Application for a non-material amendment following a grant of planning permission. Town and Country Planning Act 1990

ERECTOR OF 2 STOREY EXTN

2024/62/90423

NEW SIDE WINDOW

Drg No 24 13 Rev A

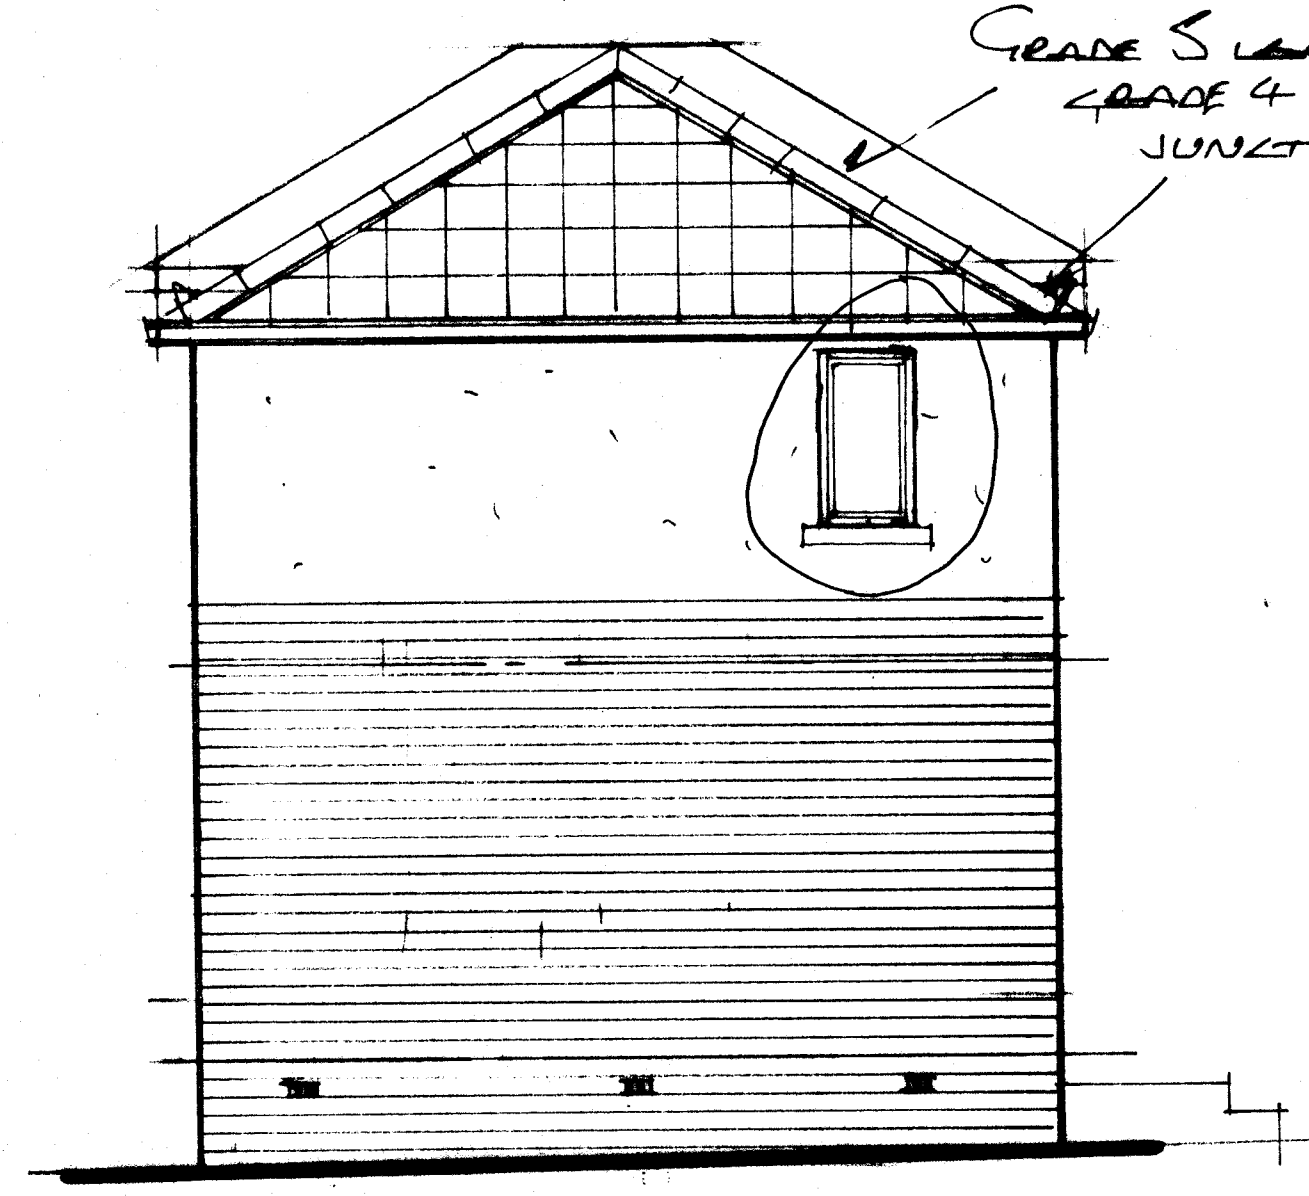
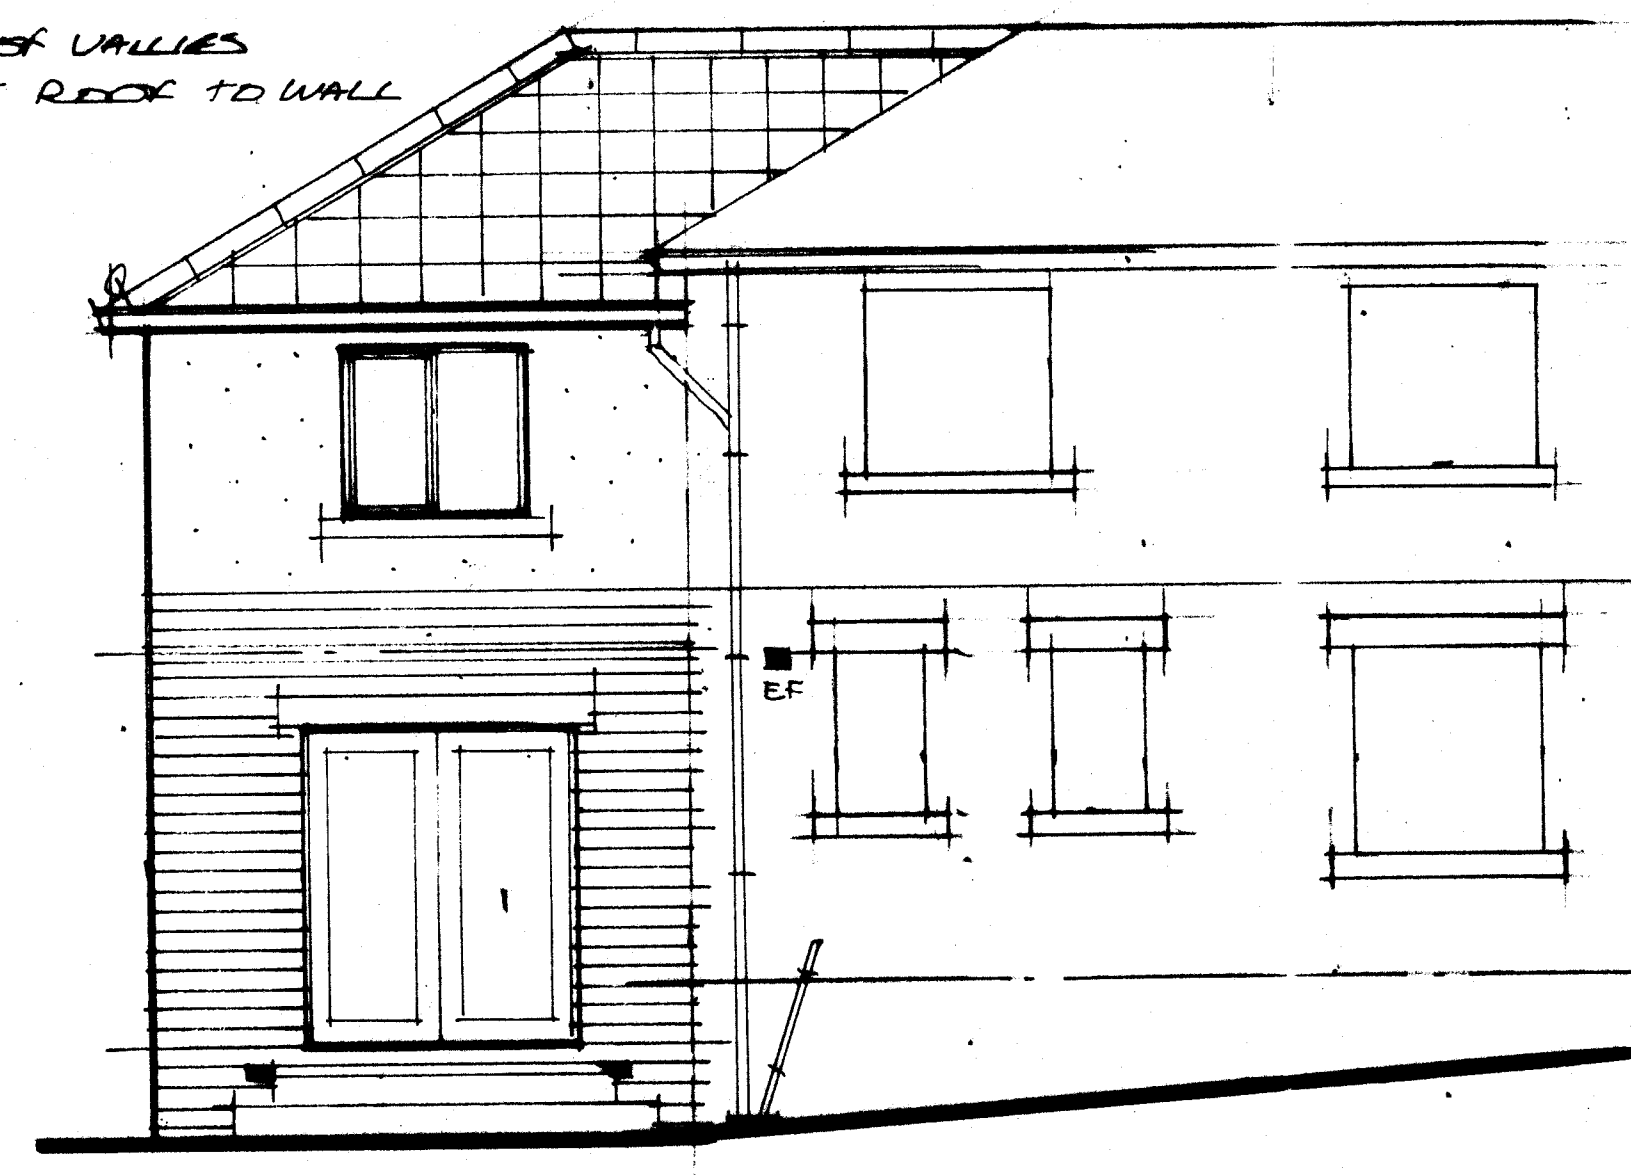
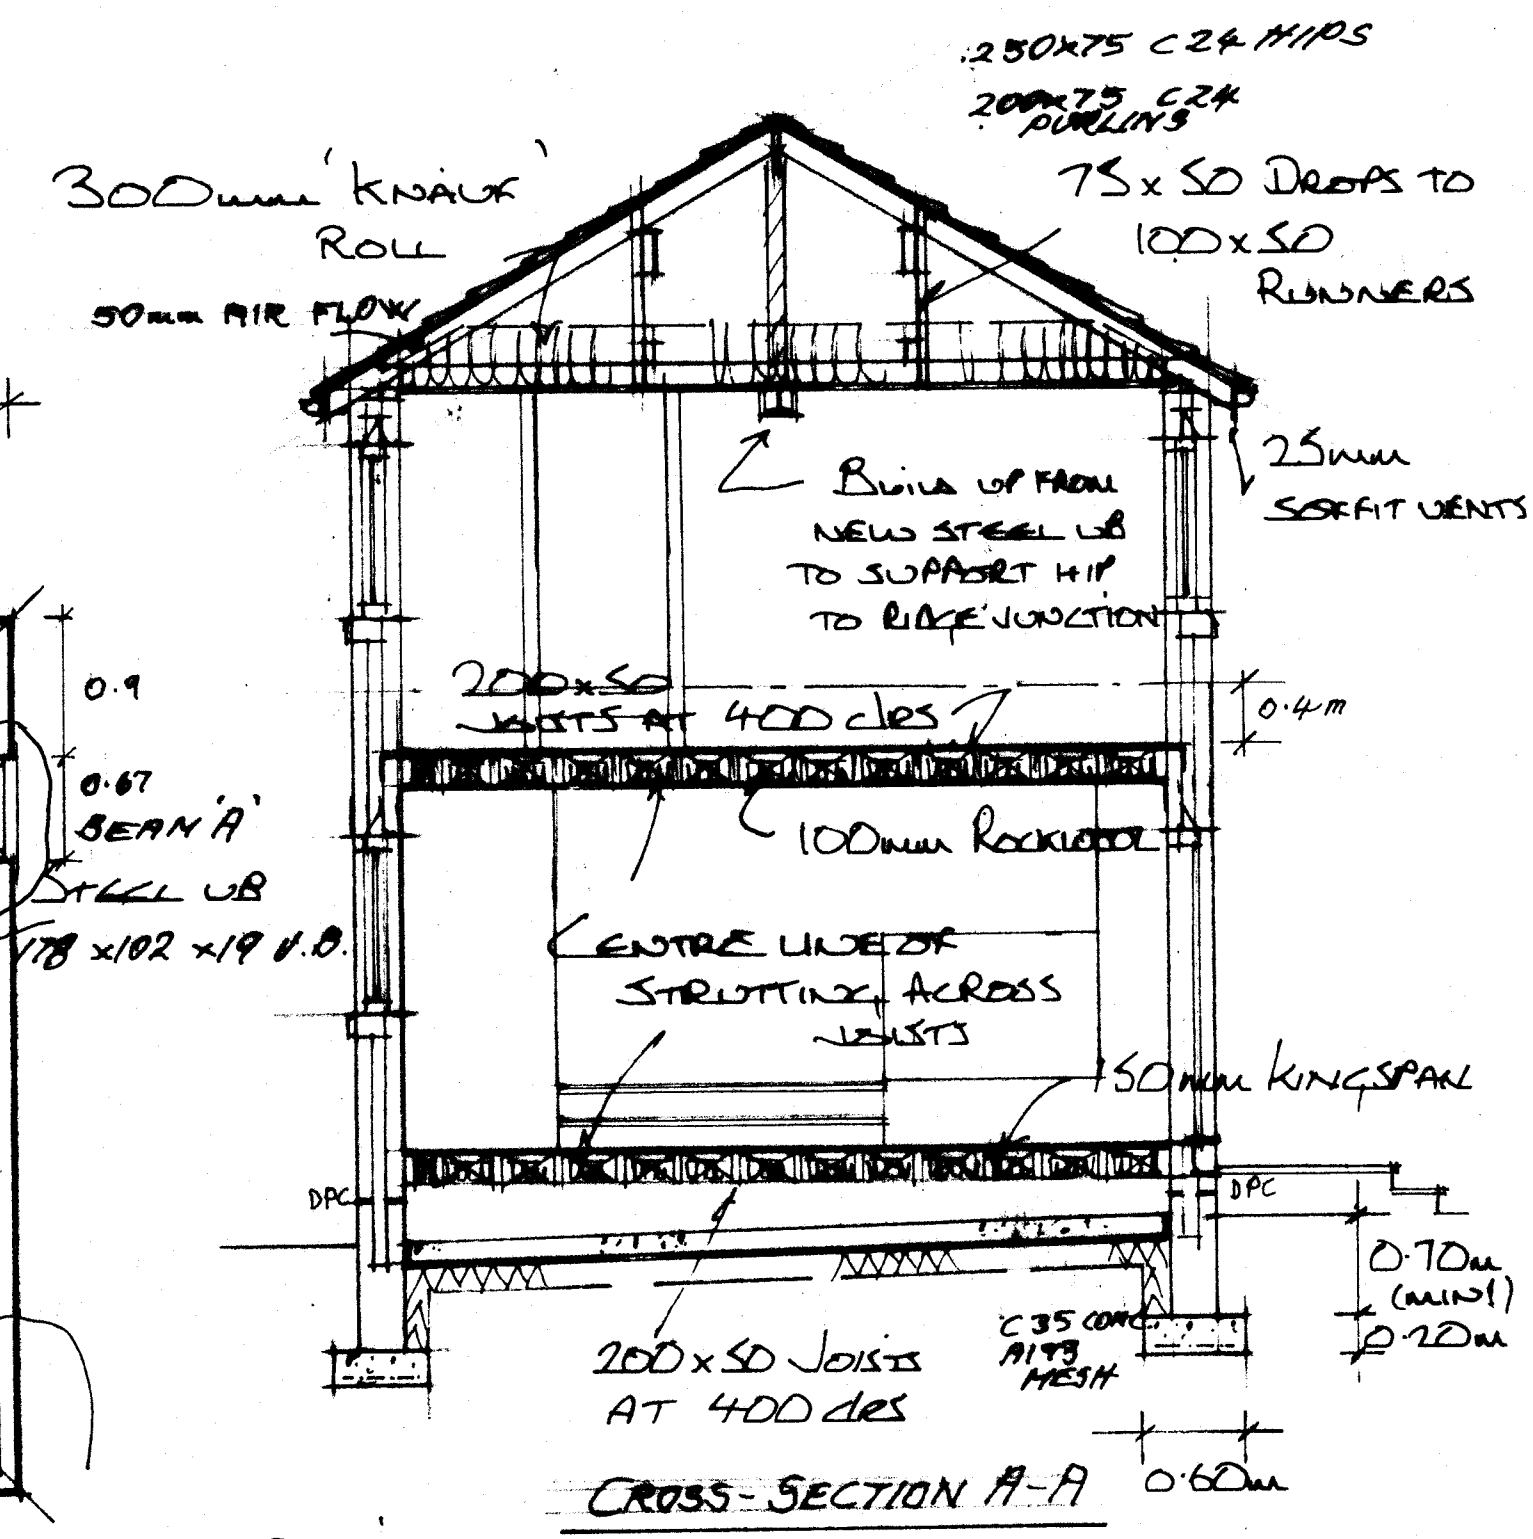
ADDITIONAL LIGHT
